**NSIP Reference Name / Code: A46 Coventry Junctions (Walsgrave) / TR010066**

**Natural England's response to the Examining Authority's first written questions.**

## Natural England's response to the Examining Authority's (ExA's) first written questions

FIGURE 2: HABITATS REGULATION ASSESSMENT - LOCATIONS OF INTERNATIONALLY DESIGNATED SITES

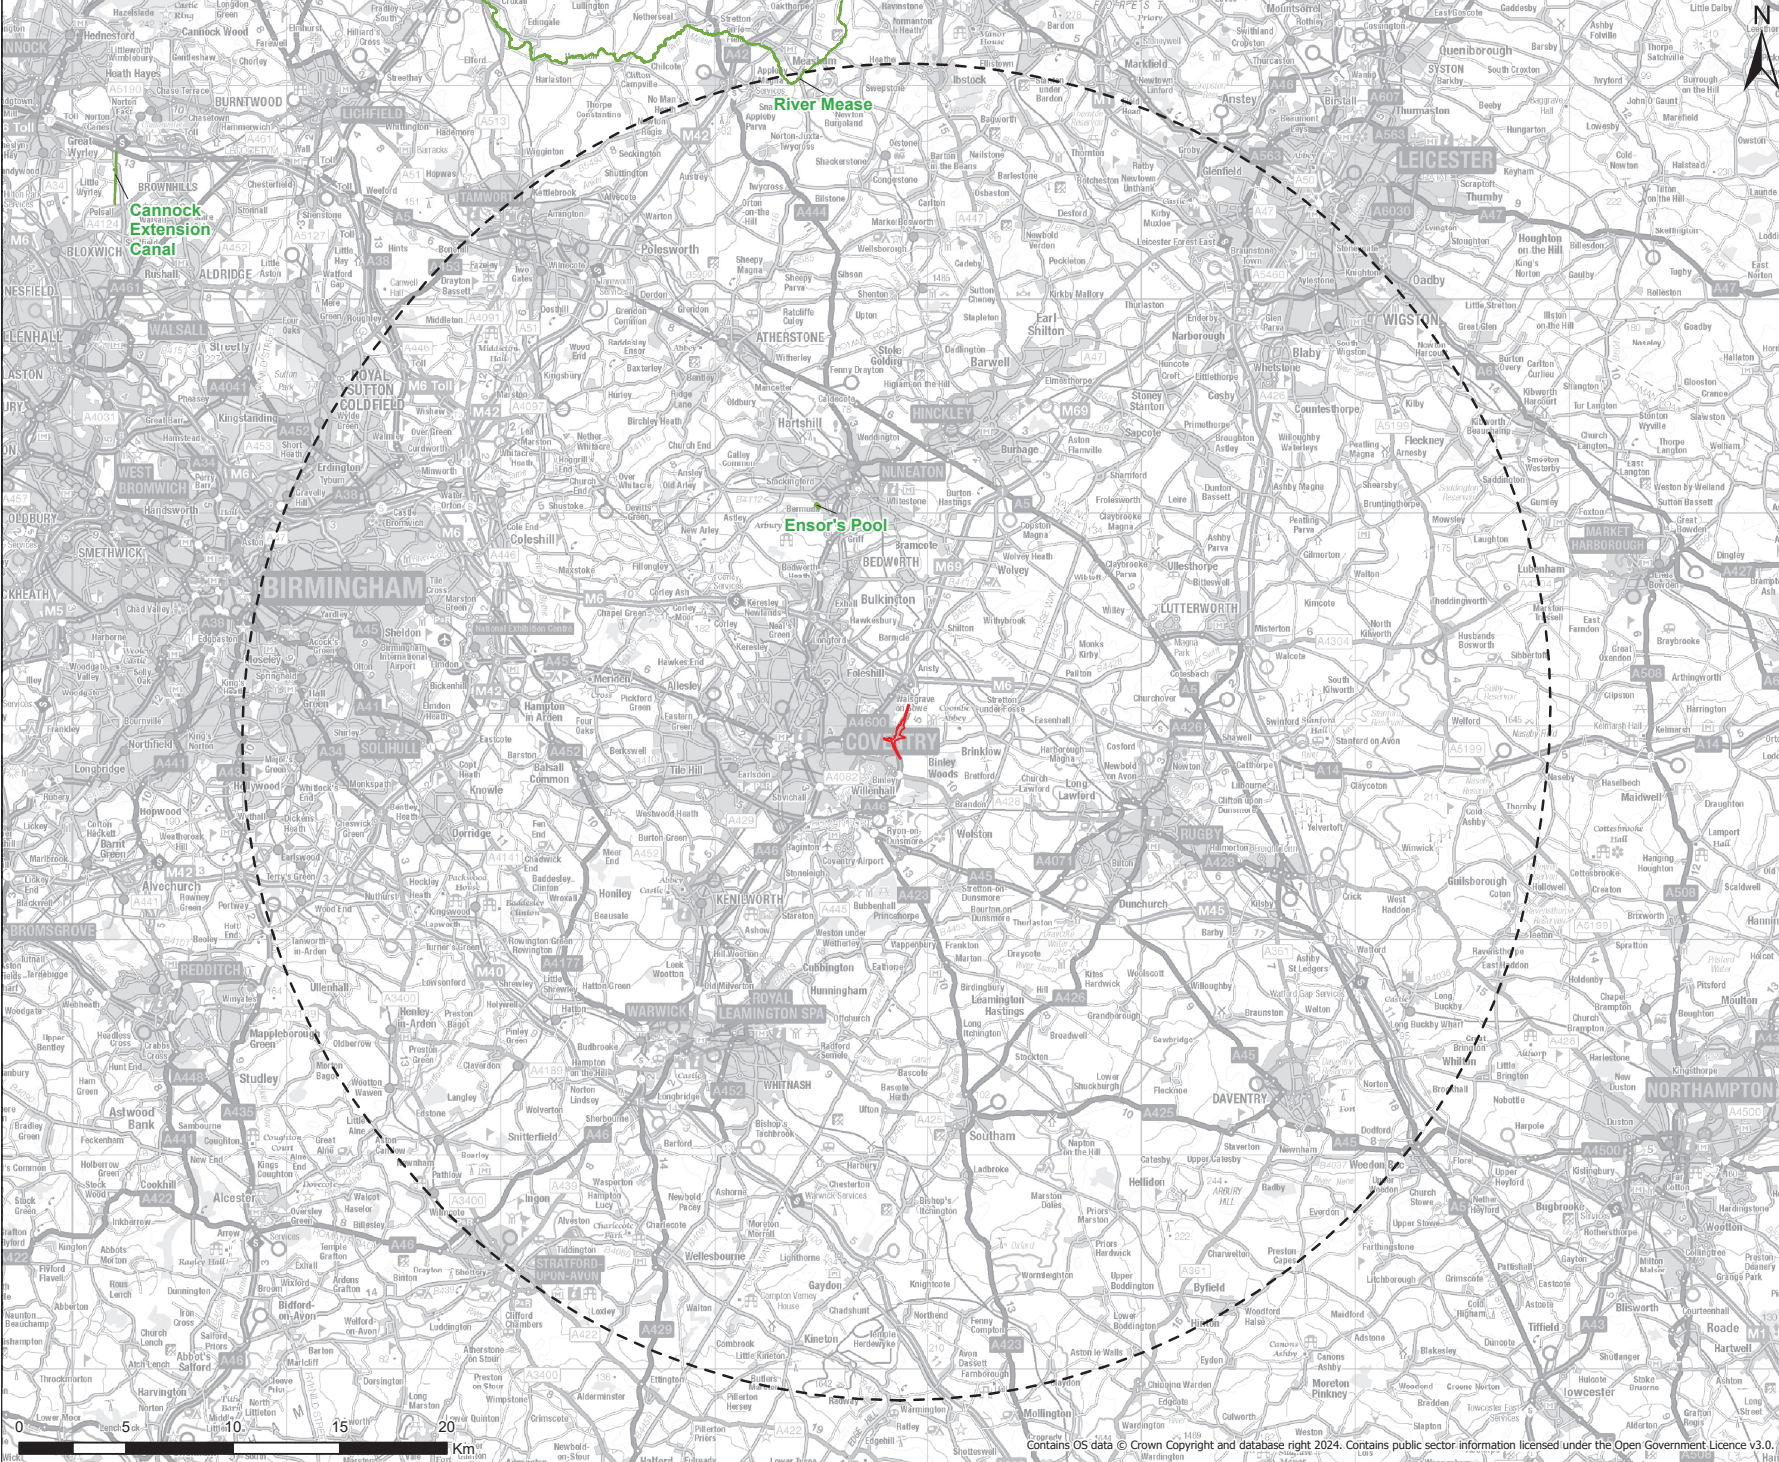
DCBY.1.9	Natural England	Habitats Regulations Assessment Confirm whether you are satisfied with the conclusions of the Habitats Regulations Assessment report? (Refer to Tables 4-1 and 4-2 of Appendix 8.12 Habitats Regulations Assessment Report [APP087]).	Natural England is satisfied with the conclusions of the Habitats Regulations Assessment report (APP087).
BY.1.10	The Applicant Natural England	Habitats Regulations Assessment The Joint Nature Conservation Committee Standard Data Form (and website information) for the River Mease SAC lists the following which have not been considered within the applicants HRA report [APP-087]: Annex I habitats present as a qualifying feature (but not a primary reason for selection of this site) Water courses of plain to montane levels with the	<p>We advise that the HRA (APP-087) should list all the qualifying features set out in page 2 of the <a href="#">River Mease SAC Citation, PDF, 40.3 kB</a> and any potential impacts to the site's Conservation Objectives</p> <p>In this instance we do not consider there to be any likely significant effects on the qualifying features of the River Mease SAC. This is because the proposal site is not in or near the River Mease catchment</p>
